**From:** Simon Davis  
**Sent:** 25 January 2018 16:48  
**To:** Planning.Responses  
**Subject:** FW: Planning Application Ref EG/69/17/PL Swallowfield Nursery, Eastergate Lane

**Subject:** Planning Application Ref EG/69/17/PL Swallowfield Nursery, Eastergate Lane

We received the comments of Eastergate Parish Council on this application on 04/09/17 stating:

Heather Godmark			
Swallowfield, Eastergate Lane			
Visibility Splays and Swept Path Analysis			
Varies @ A2	SMO	ALB	PMR
October 2017	2016/3448/001		C

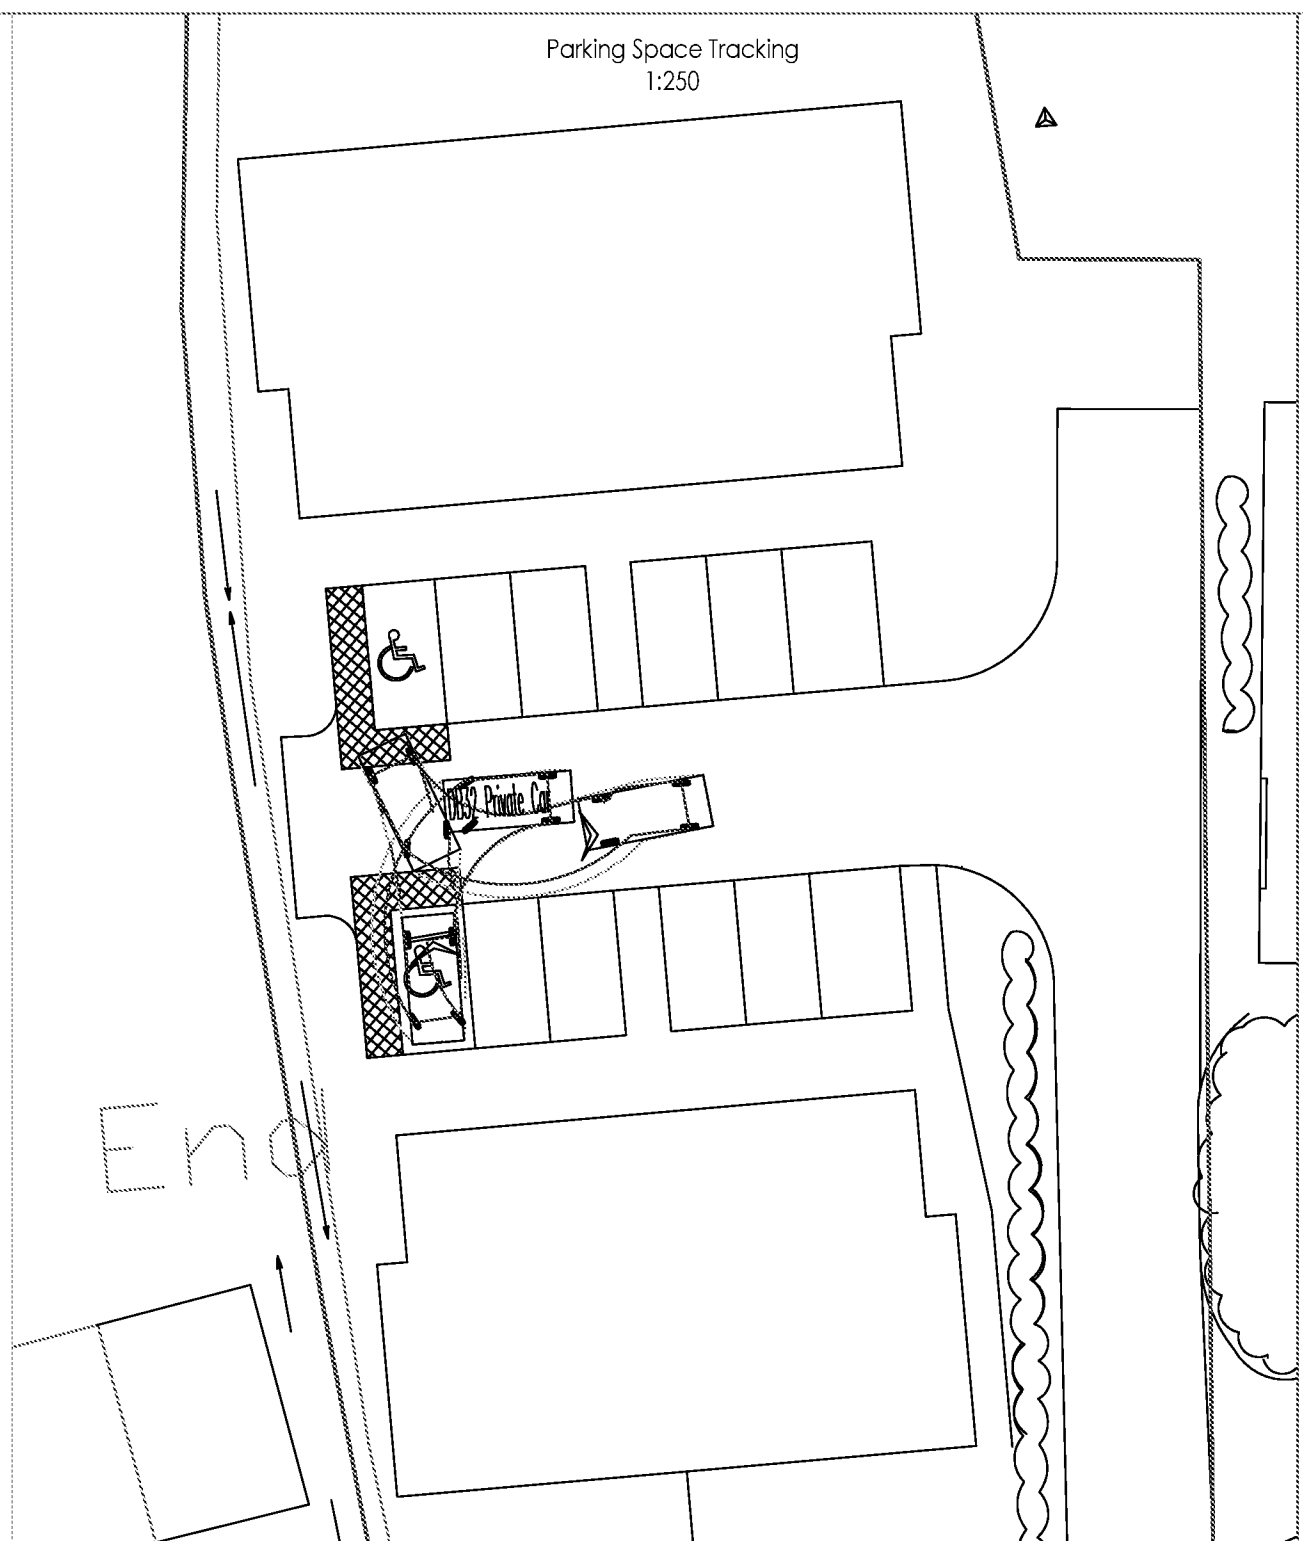
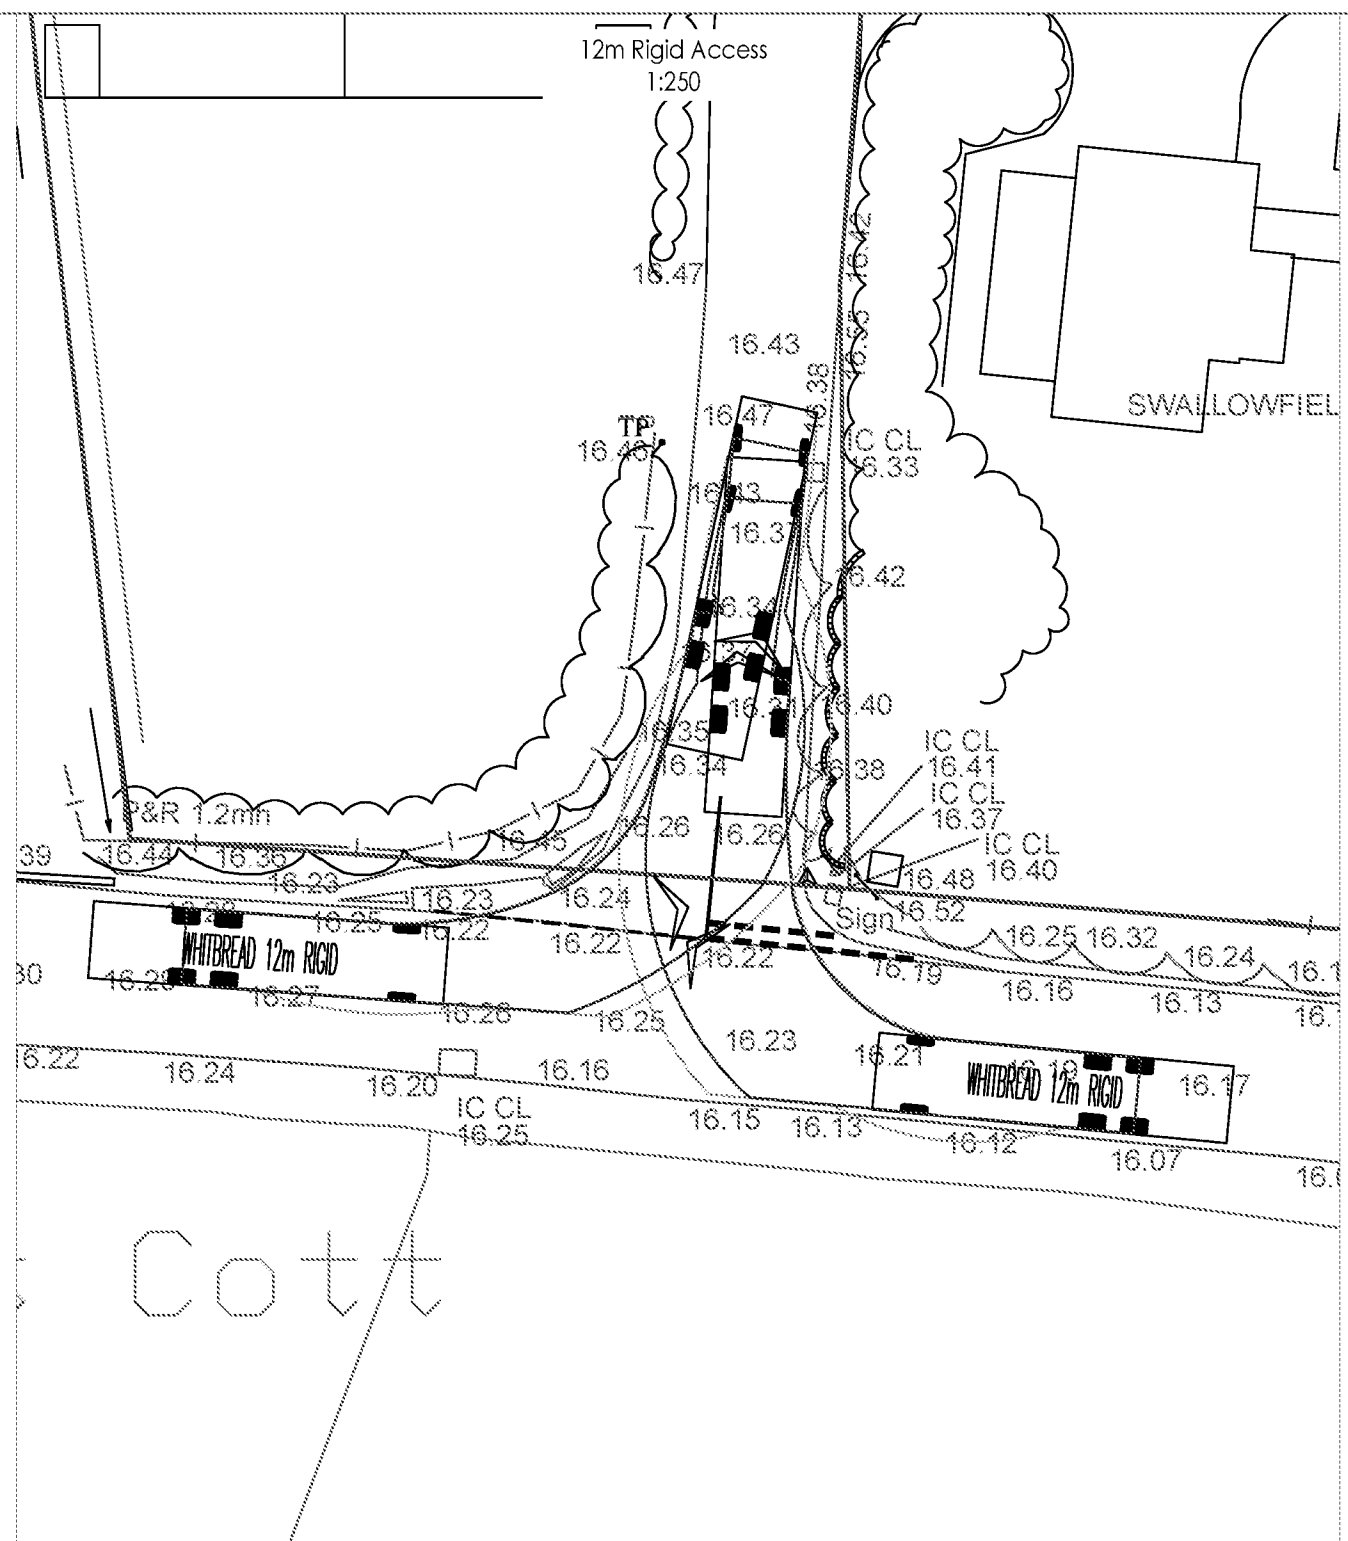
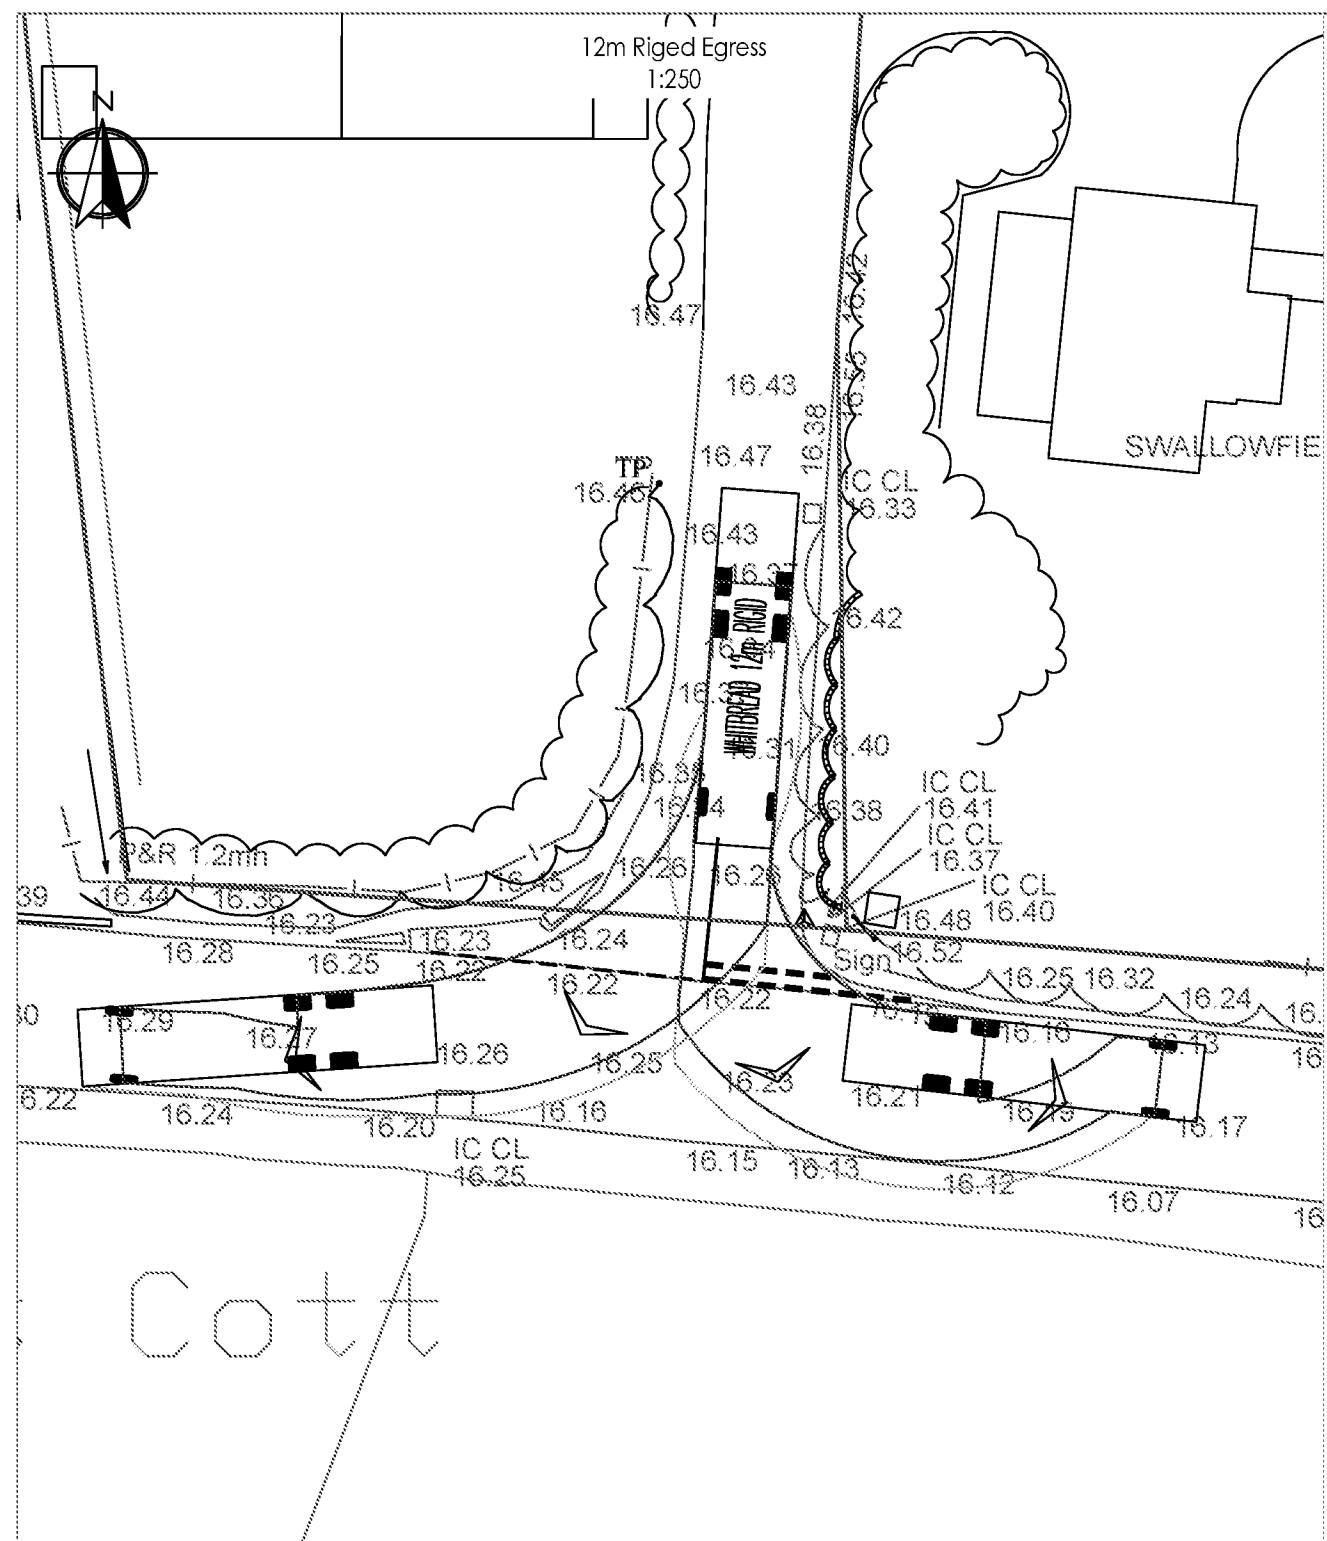
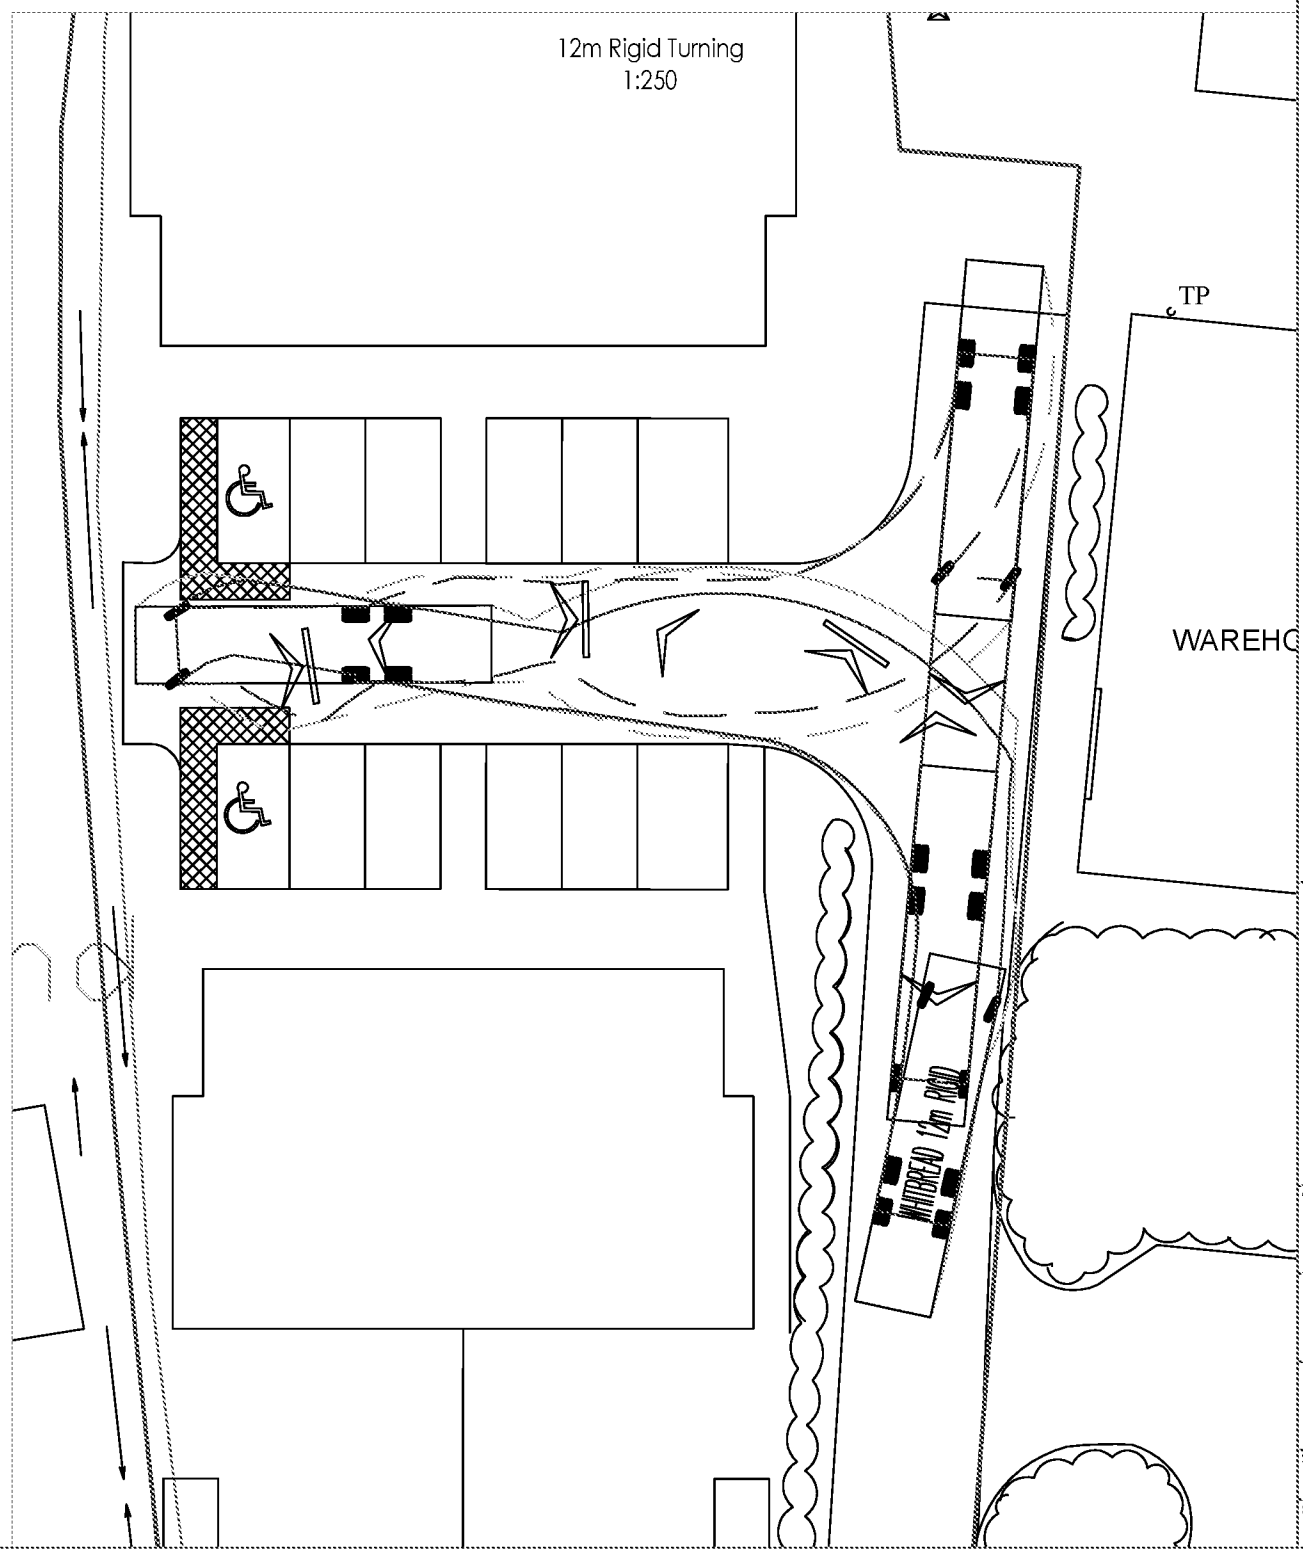
*"OBJECT. The council considers that the application should not be permitted without an allocation of space, on site, for articulated and other vehicles to turn. A condition requiring the use of such turning space should, if possible, be added to any permission."*

We have received a WSCC Highways response which confirms that the turning space on the site would be suitable for larger vehicles including refuse collection and fire appliances. I then asked WSCC Highways about articulated lorries and they commented that they cannot be 100% sure that an articulated lorry could turn with the live/work unit section of the site because of the limitations of the drawings. However, they are mindful of the existing layout with the greenhouses and that with regard to space available to turn on site, this does not appear to be materially different from the existing situation. Furthermore with the reduction in greenhouse at the site & proposed use as live/ work light industrial units. WSCC Highways also question the need for an articulated lorry to serve the site at all.

The applicant has commented that articulated lorries have never been able to turn on the site but also that they have never caused a problem. Visits by articulated lorries are rare but when one does visit, they are supervised and reverse into the site entrance thus allowing them to unload and then exit in a forward gear. It is also contended that the research facility & small live-work units will generate modest levels of traffic and very few commercial movements. The largest vehicles that will service them would be refuse vehicles, which already access and can turn on-site. Also with the reduction in glasshouse space proposed there will be even less reason for articulated lorries to visit the site.

I apologise for my tardy reply. I have been unwell. The Parish Council maintains the view that a turning place for large vehicles would be best but, in view of the ADC position, the council withdraws it's objection and leaves the District council to make the decision.

Please note also that we are unable to impose a planning condition to address an existing issue (occasional visits by articulated lorries) that is not related to the proposal the subject of the planning application.

I therefore write to ask if the Parish Council would withdraw their objection and allow the application to proceed with a delegated decision.
